STRUCTURAL PERMIT CORRECTIONS

RE Permit corrections for Koneru Residence at 6610 E Mercer Way, Mercer Island, WA 98040, Permit No. 2112-250

We have received and reviewed the STRUCTURAL comments (REV3-SUB2) regarding the revised stair structure on 6610 E Mercer Way project, permit number 2112-250. Below are the corresponding responses to the structural comments for the correction notice prepared by Don Cole dated May 17, 2024:

OPEN RISER STAIR - UPPER SECTION
SCALE: 3/4" = 1'-0"

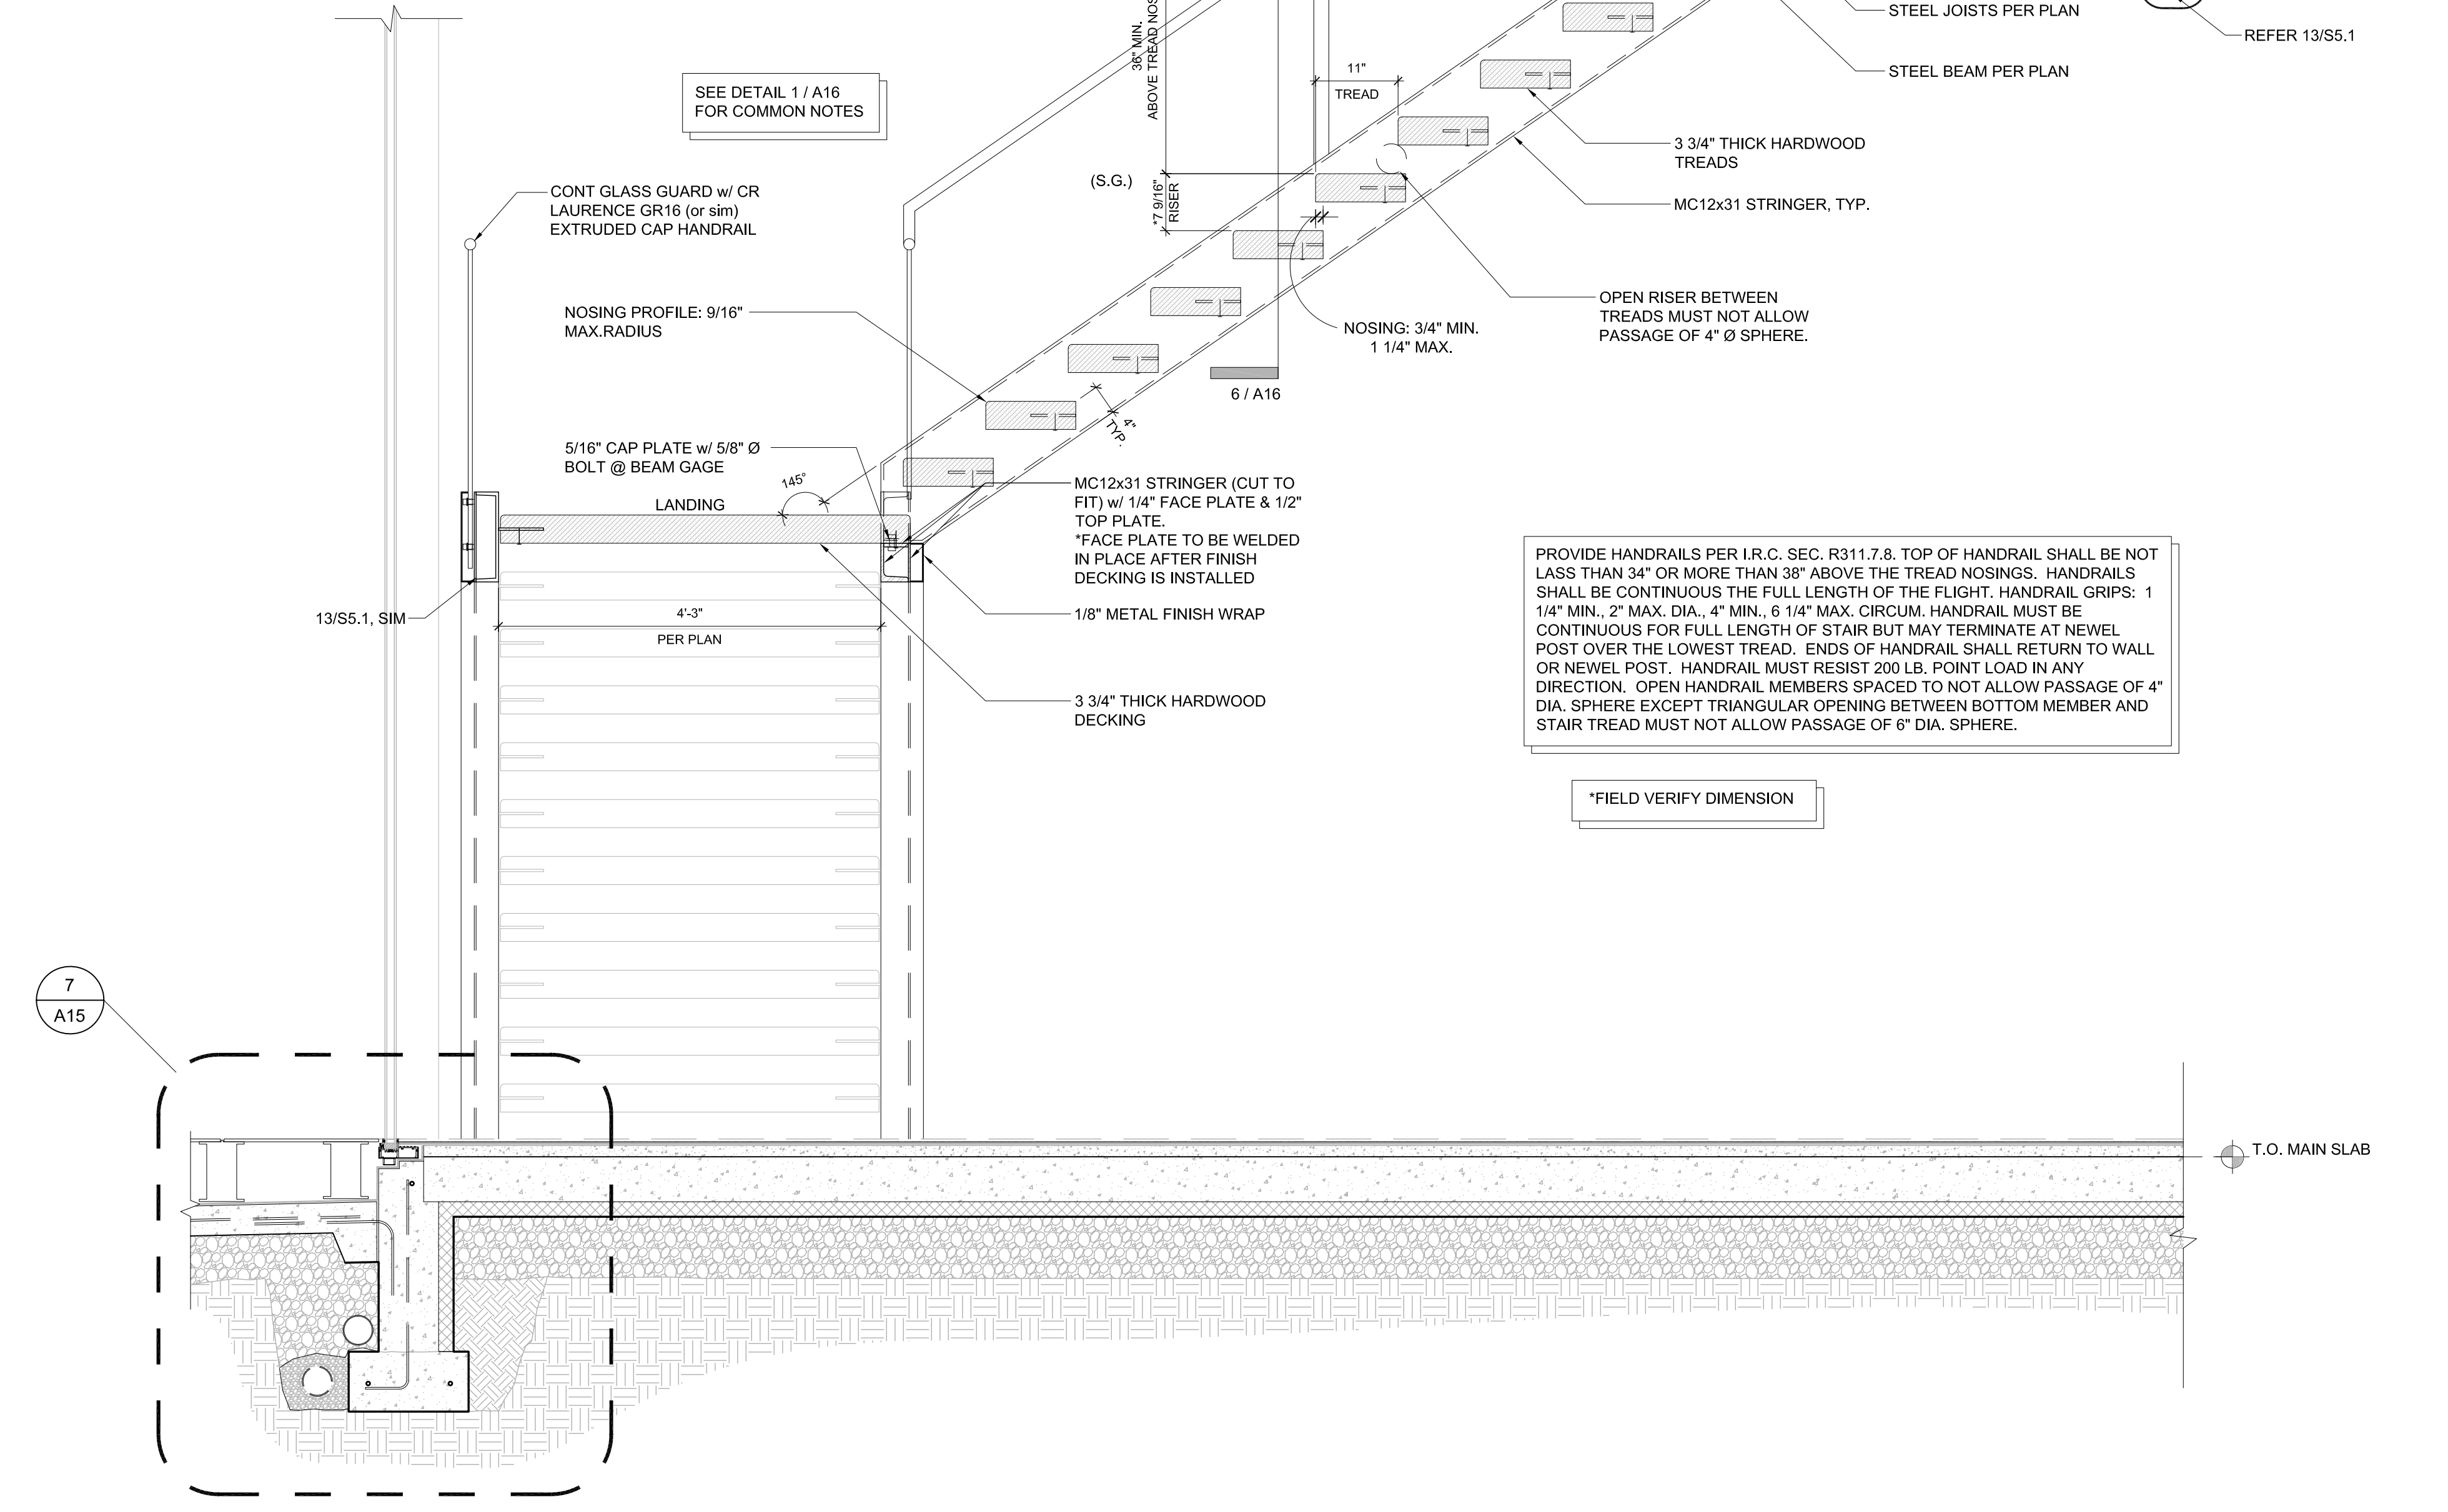
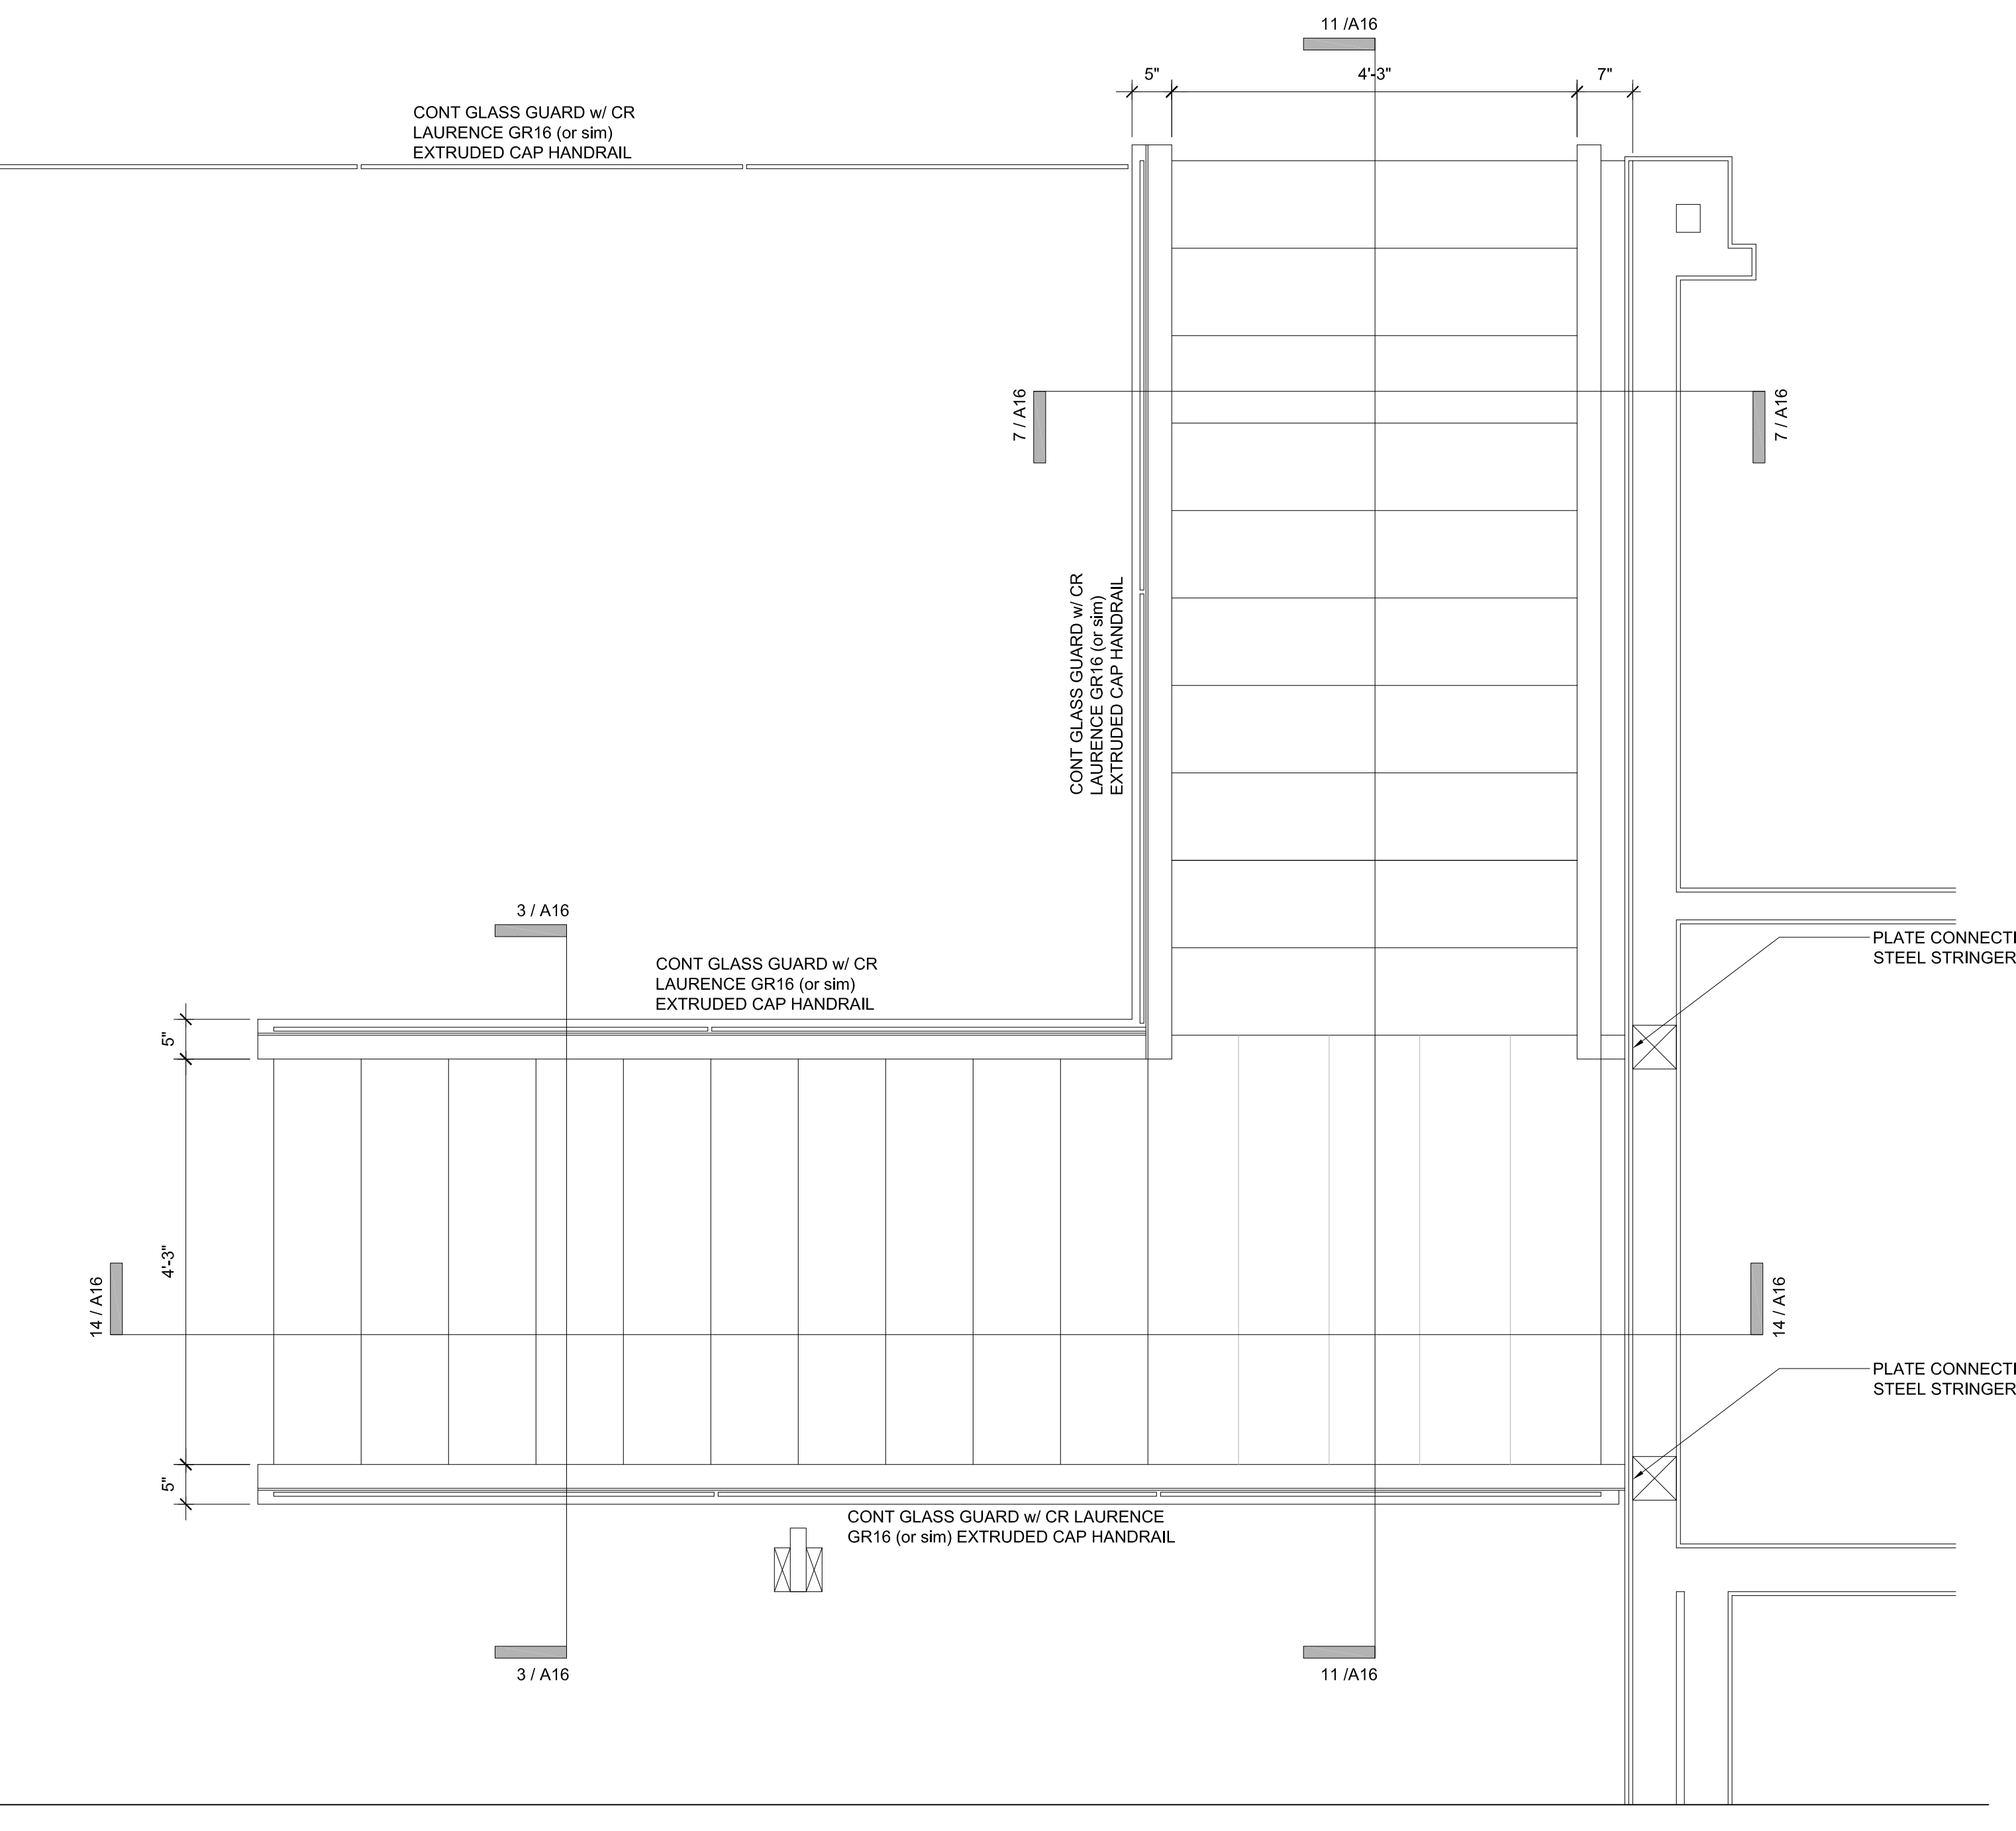
1. Load induced by the stair stringers will be supported with 1/2" thick x 2'-0" wide x 4'-6" long steel plate at the base of the stair and a combination of structural slab on grade underneath the steel plate over grade beam with pin pile support, please see supplemental calculations dated May 30, 2024.
